Sent: 27 November 2009 15:48  
To: Planning  
Subject: Welwyn Hatfield Council Online Planning - Comment

Application Number: S6/2009/2110/FP  
Name: dirk vanderpant  
Address: 16 gooseacre  
welwyn garden city  
herts al7 4nb

Project 36 Theobalds Road Cufley  
Drawing Proposed elevations  
Format A3

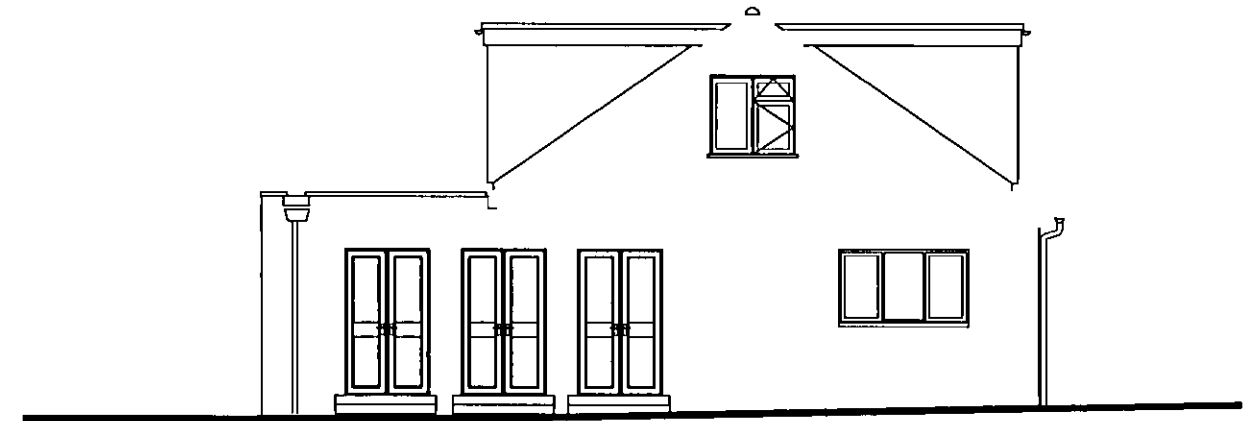
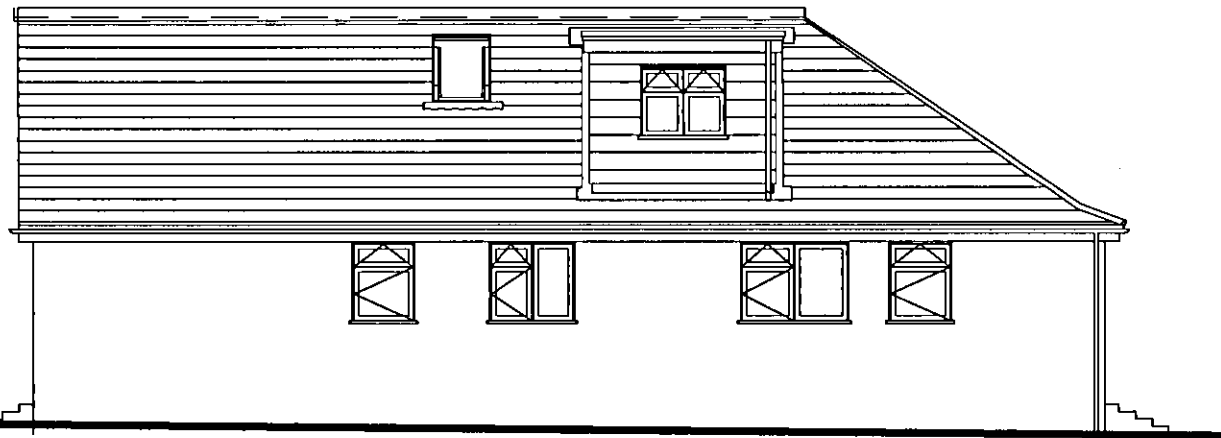
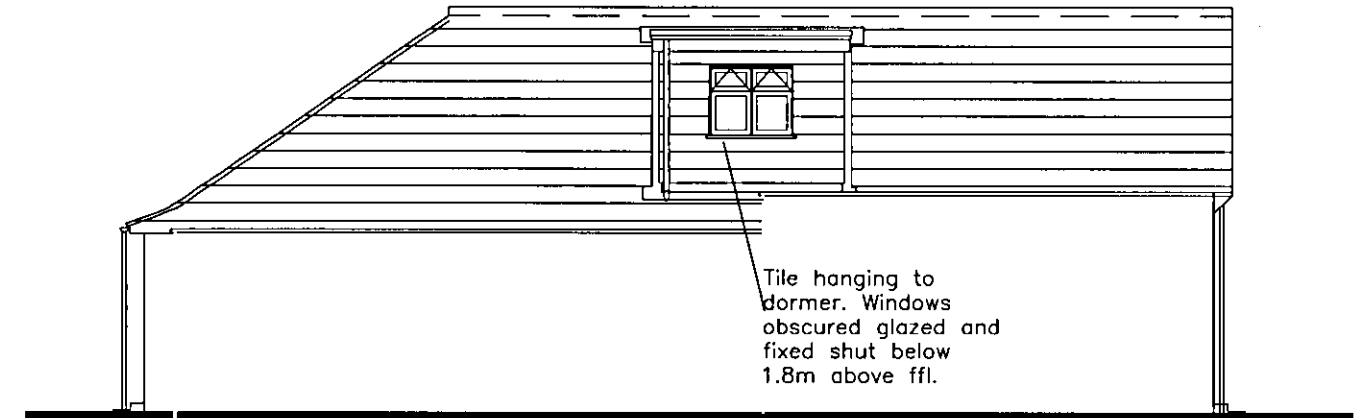
Comment: The current application with such a high wall (10 feet high) forming the boundary between no 36 and 34 will have the effect of blocking out a lot of light from my mothers windows and property running as it will for some 6.5 metres from the back of no 36. We simply feel that at 10 feet high the wall is too tall !
